Re: Planning Application 2020/0281

Address: Lower Seed Farm Stoneygate Lane Ribchester PR3 2ZS

Description: Demolition of existing two storey farmhouse and six outbuildings and construction of one single storey replacement dwelling.

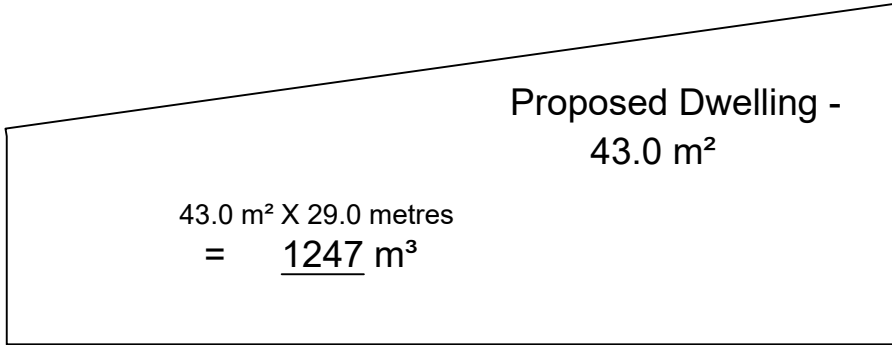
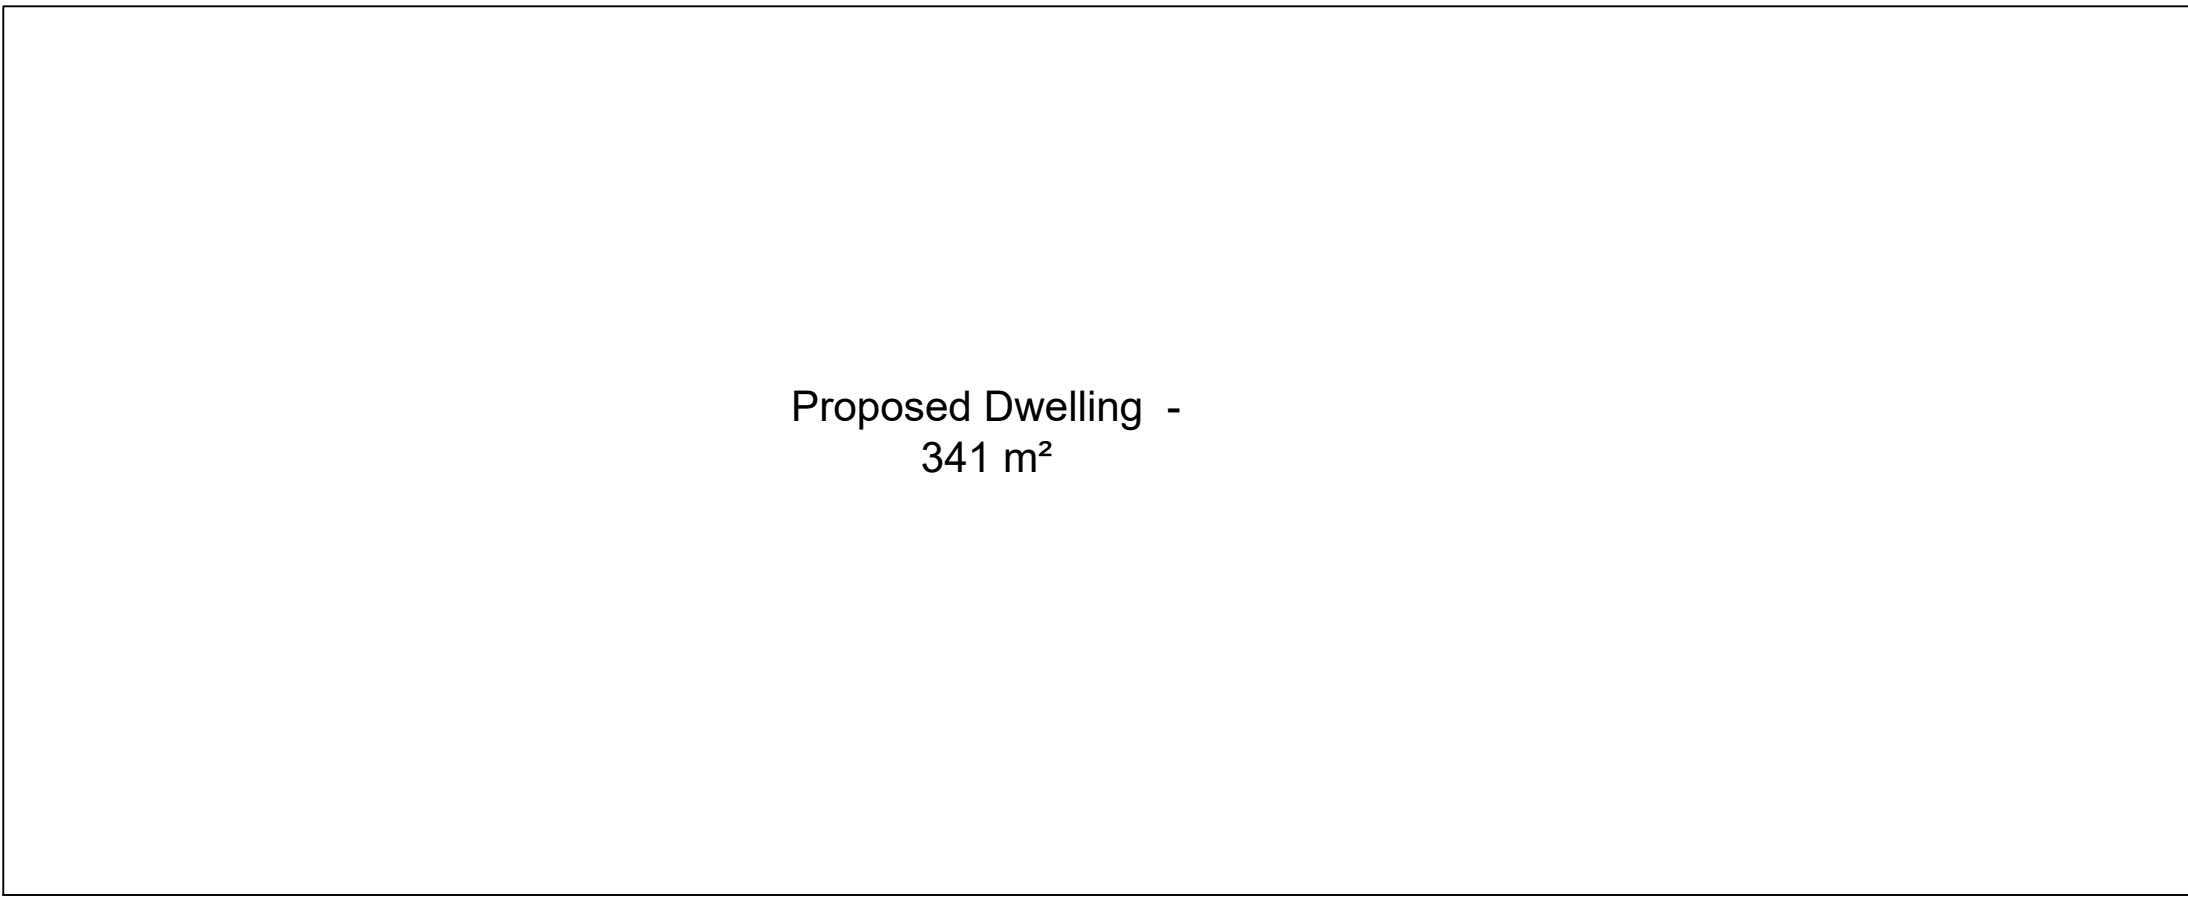
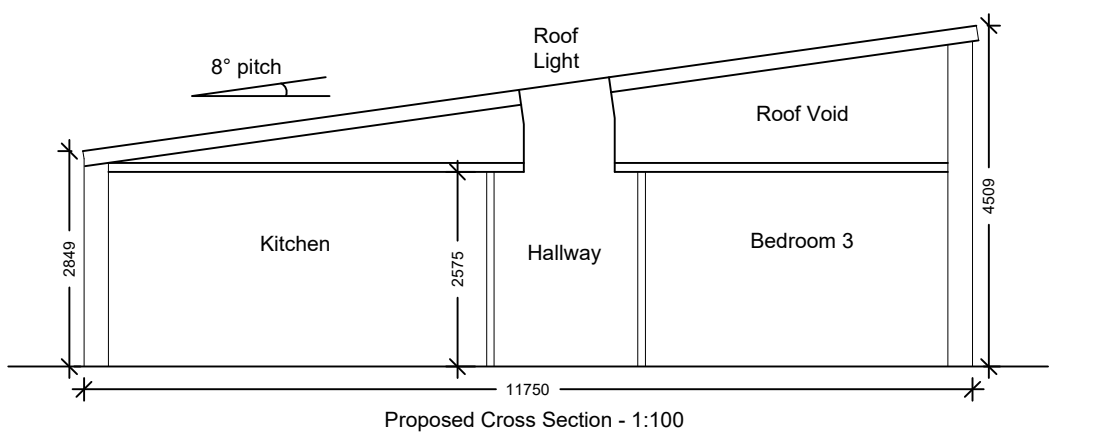
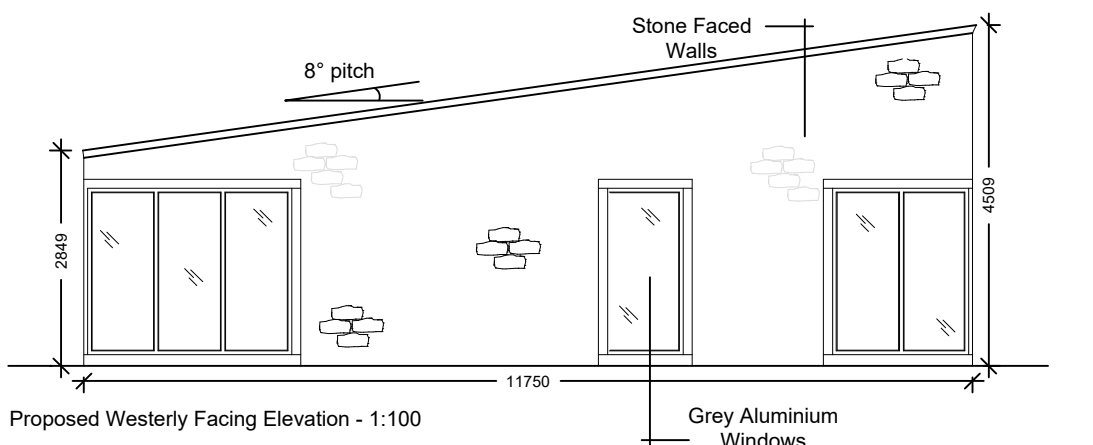
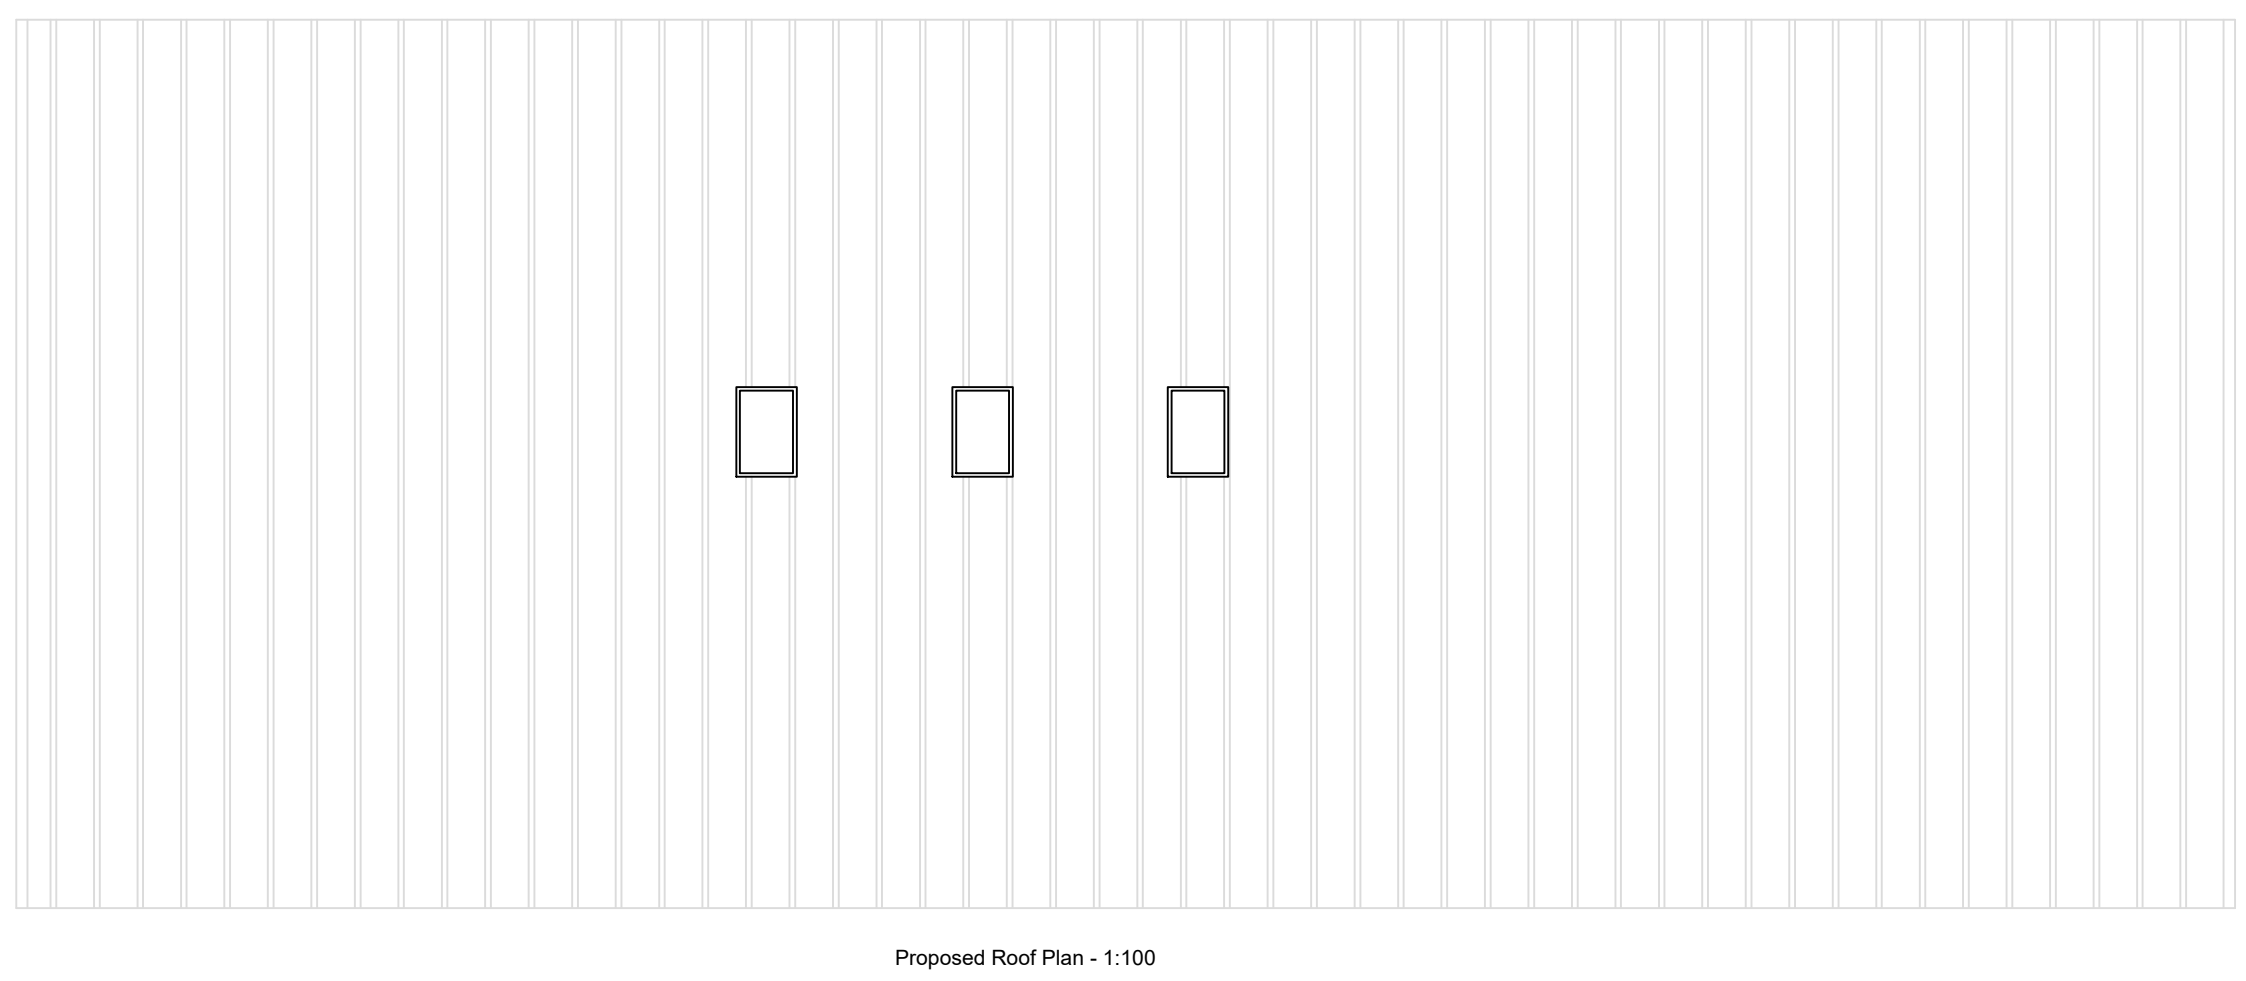
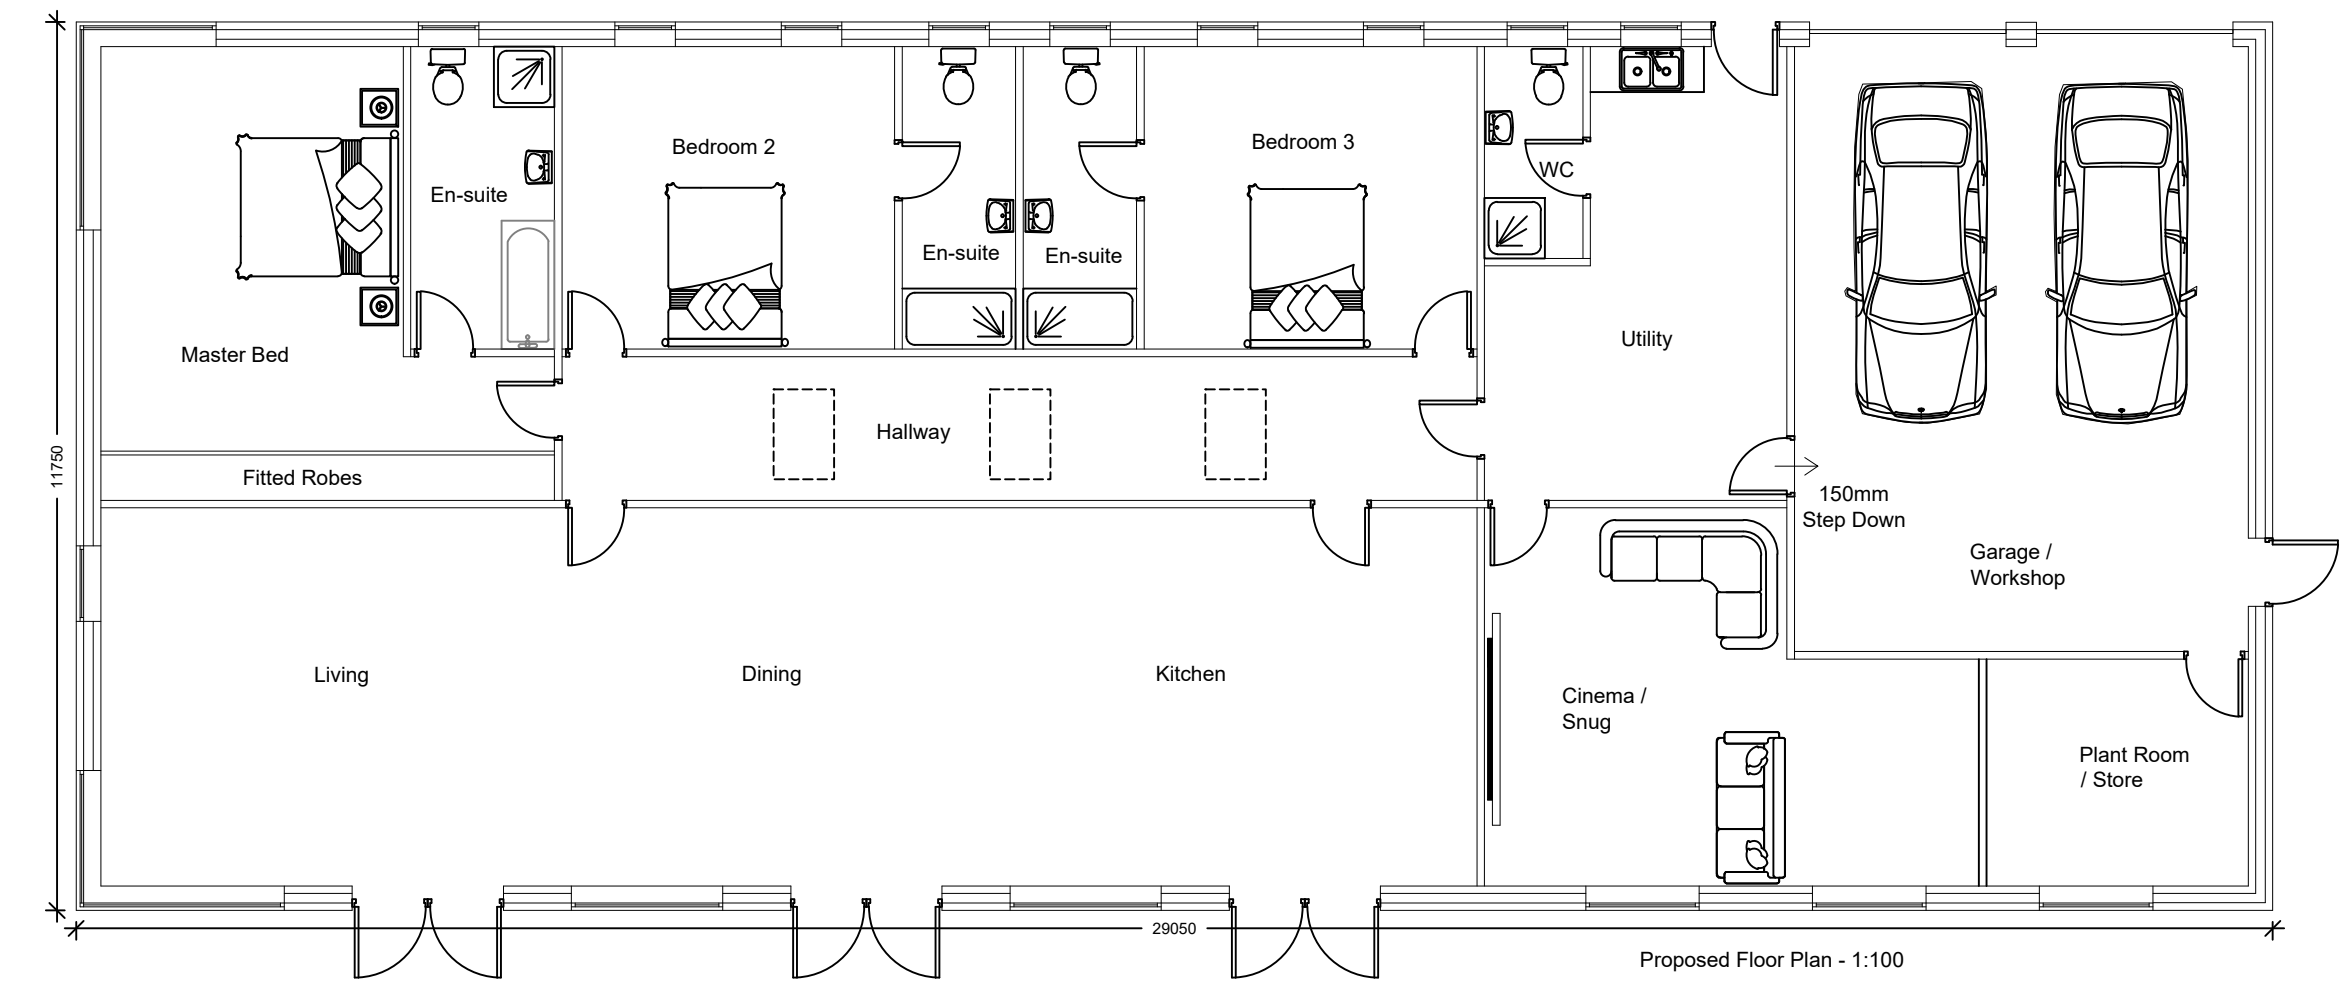
With respect to this application whilst we would not wish to raise an objection to the application in principle. There is a concern regarding the site lines from the driveway to the farm access lane leading to Stoneygate Lane.

In order to progress the application we would look for a plan showing the sight lines, from the driveway. These shall be measured 3m back from the edge of the farm access lane at the centre of the driveway, with a splay of 45° in either direction. The sight line splays will require walls, fences, trees, hedges, shrubs, ground growth, structures etc. to have a maximum height of 1.0m above the height at the centre line of the adjacent carriageway.

1. Prior to first occupation the sightlines from the new 3m back from the edge of the farm access at the centre of the driveway, with a splay of 45° in either direction. The sight line splays will require walls, fences, trees, hedges, shrubs, ground growth, structures etc. to have a maximum height of 1.0m above the height at the centre line of the adjacent carriageway.
